**Notice of Intent to SUSPEND/REVOKE Improvement Permit/Construction Authorization**  
07-17-2023

Subject: Notice of Intent to Suspend **SFD2207-0048** Improvement Permit/Construction Authorization

The Harnett County health department inspected the site for the on-site wastewater system located at 177 Solomon Dr, Cameron NC 28326 for compliance with General Statues 130A-334 to 345, 15A NCAC 18A .1900 et seq., and Construction Authorization SFD2207-0048 conditions. As a result of this inspection, the Department has determined the following violations:

Harnett County Department of Public Health Site Sketch

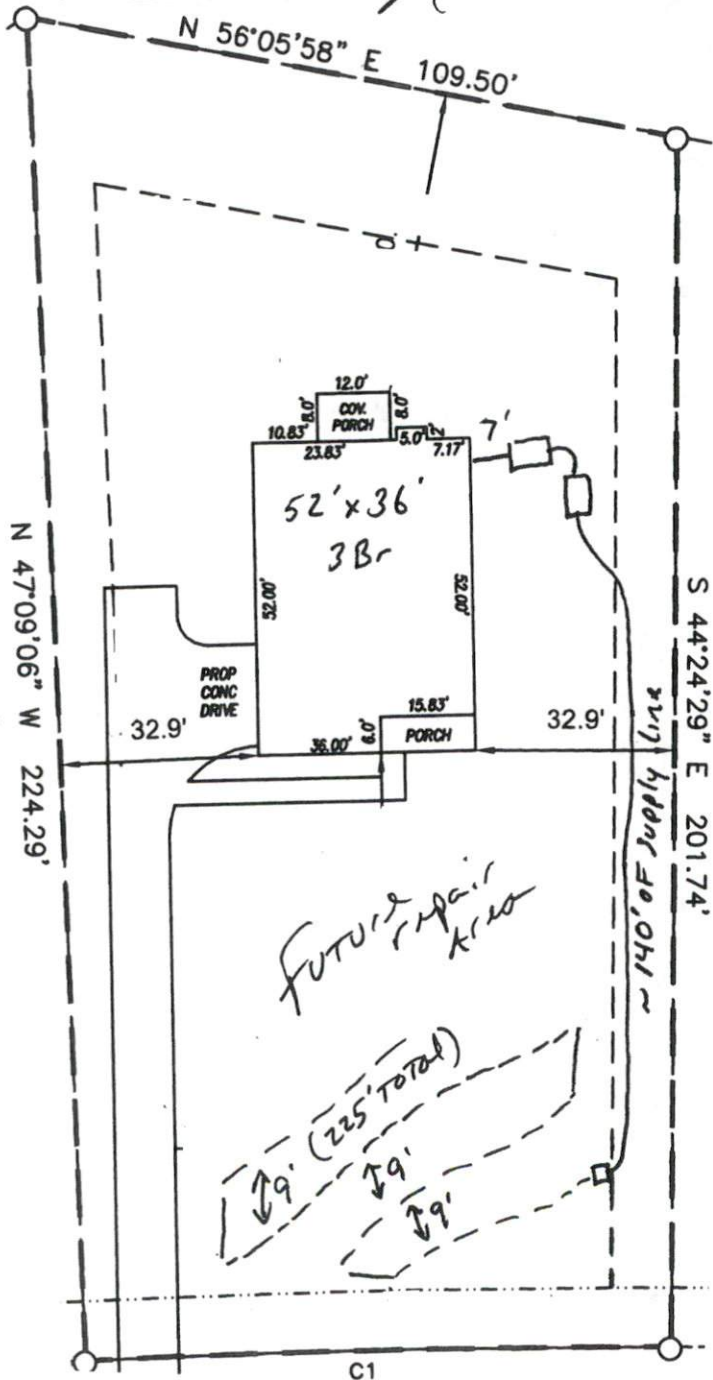
<u>Violation</u>	<u>Law or Rule Citation</u>
Site has been altered. 1 to 4 inches of soil has been removed or moved from the septic area and septic repair area in violation of G.S. 130A-335(f), Rule .1922(a), Rule .1945(b)
